**ADC Planning Consultation
Conservation/Design Officer Response**

Application Number	R/131/17/PL
Address	Land Adjacent to Abbots Lodge, 85 The Street, Rustington
Description	New development within the setting of a listed building in a conservation area
Case Officer	David Easton
Date	19 July 2017

SITE PLAN SCALE 1:200 @ A3

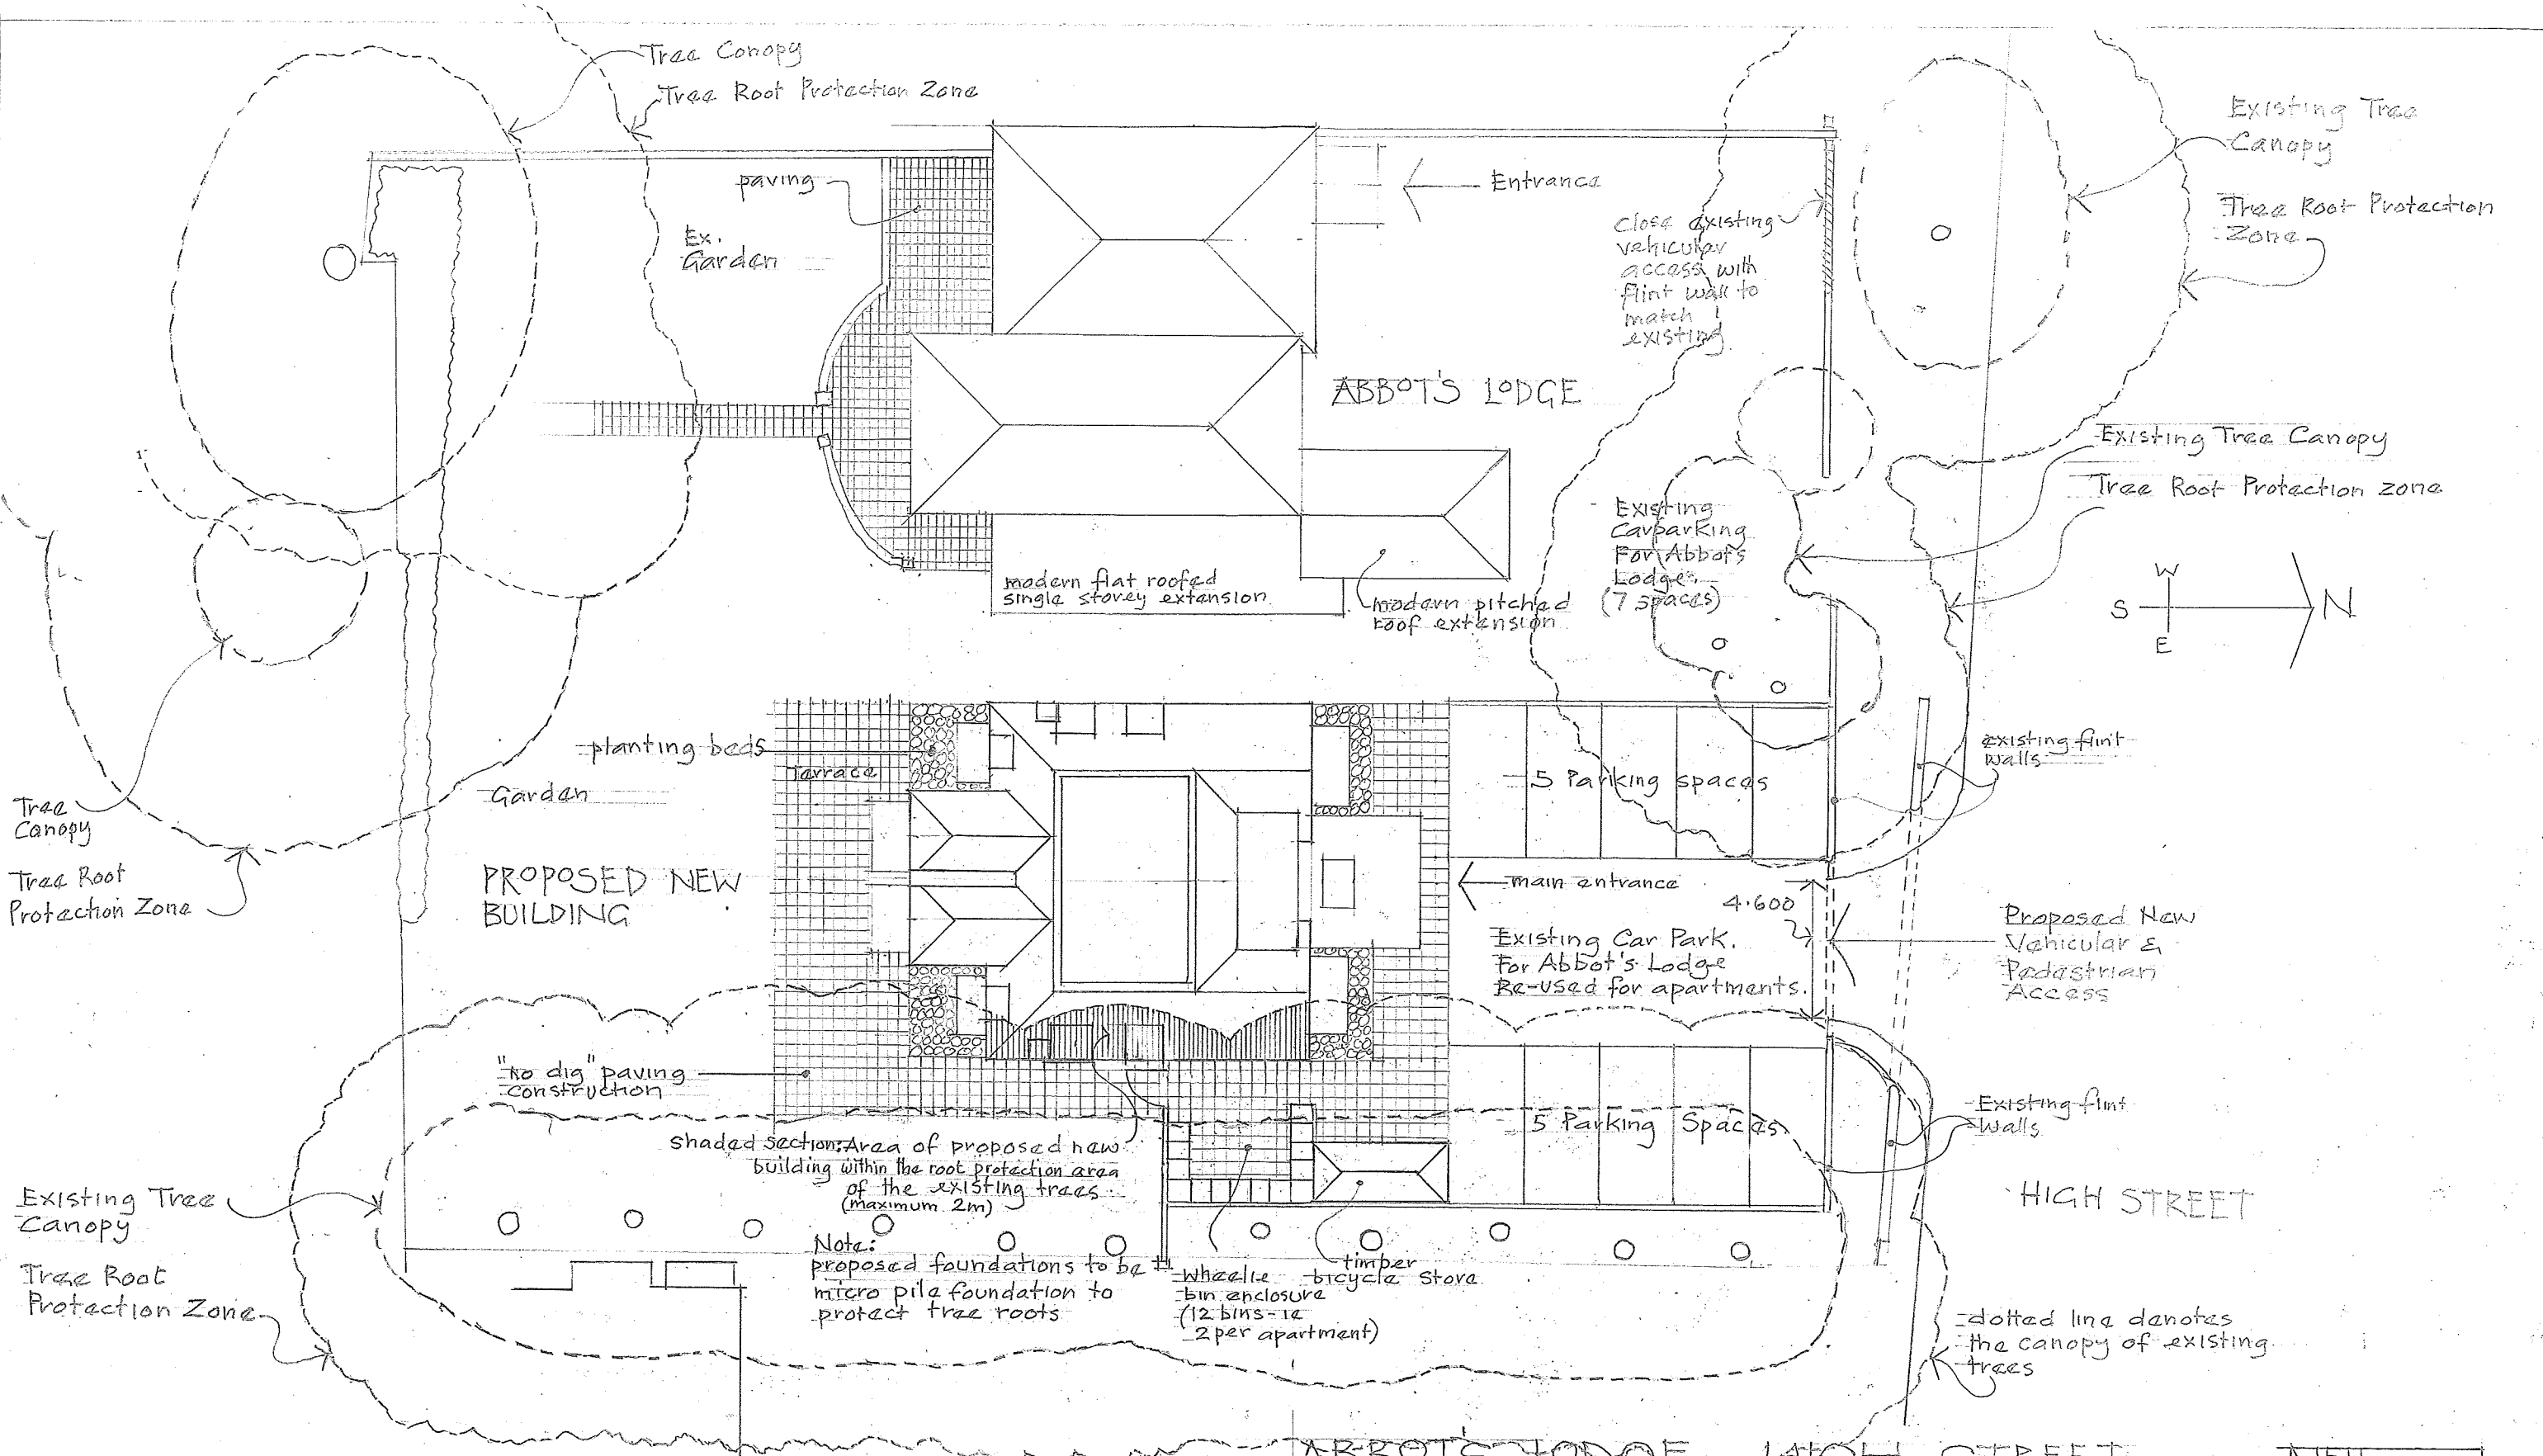
The former Vicarage was intended to sit within softly landscaped gardens and the quality of the setting has been compromised by the parts fronting The Street being converted into a car-park. However, the openness of the area defined as 'the site' continues to act as a buffer between the historic built form to the west and modern development to the east, and the space is clearly reminiscent of its original garden use. Its undeveloped nature is thus important to an understanding and appreciation of the listed building, and any form of development in such close proximity will diminish the significance of the heritage asset.

The proposal considerably intensifies the level of development on the edge of the conservation area and the assertive new built form intrudes into views to and from the designated area. Development of the site also results in the loss of a partially landscaped, open space which presently allows views across it from The Street. The proposed development thus harms locally distinctive qualities of the streetscene and in consequence, diminishes the significance of the conservation area as a whole.

NORTH ELEVATION [Proposed Apartments]

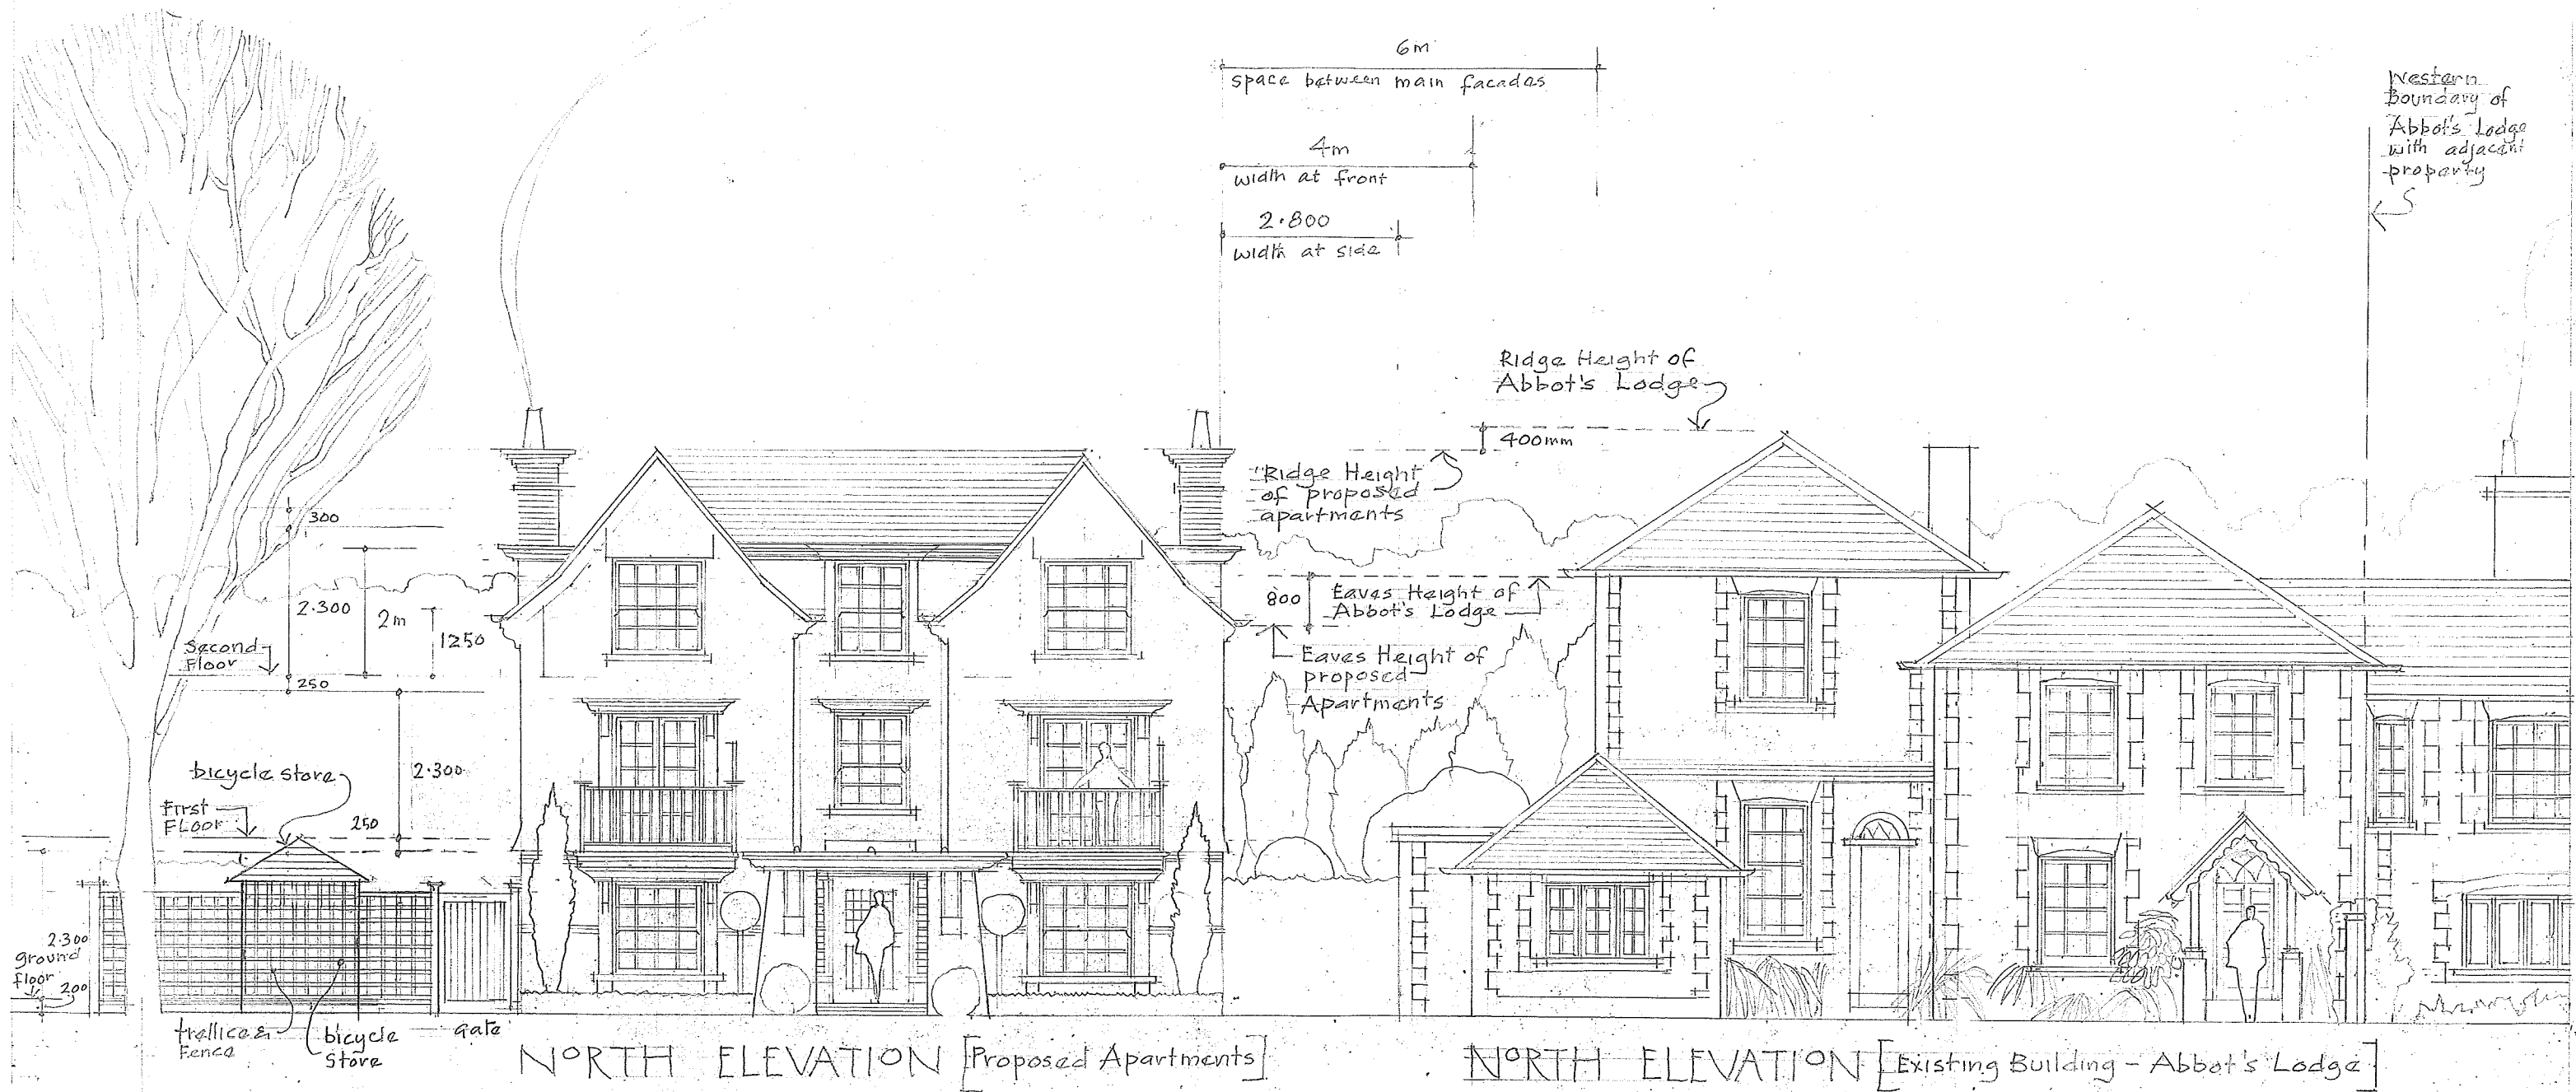
Notwithstanding the fundamental objection to development of the site, the assertive form of the new building will compete with - and distract attention from - Abbots Lodge. It is noted that the ridge of the new development is marginally lower than the highest ridge of the listed building. However due to the alignment of the respective ridges, the new development appears dominate the heritage asset and diminish its pre-eminence.
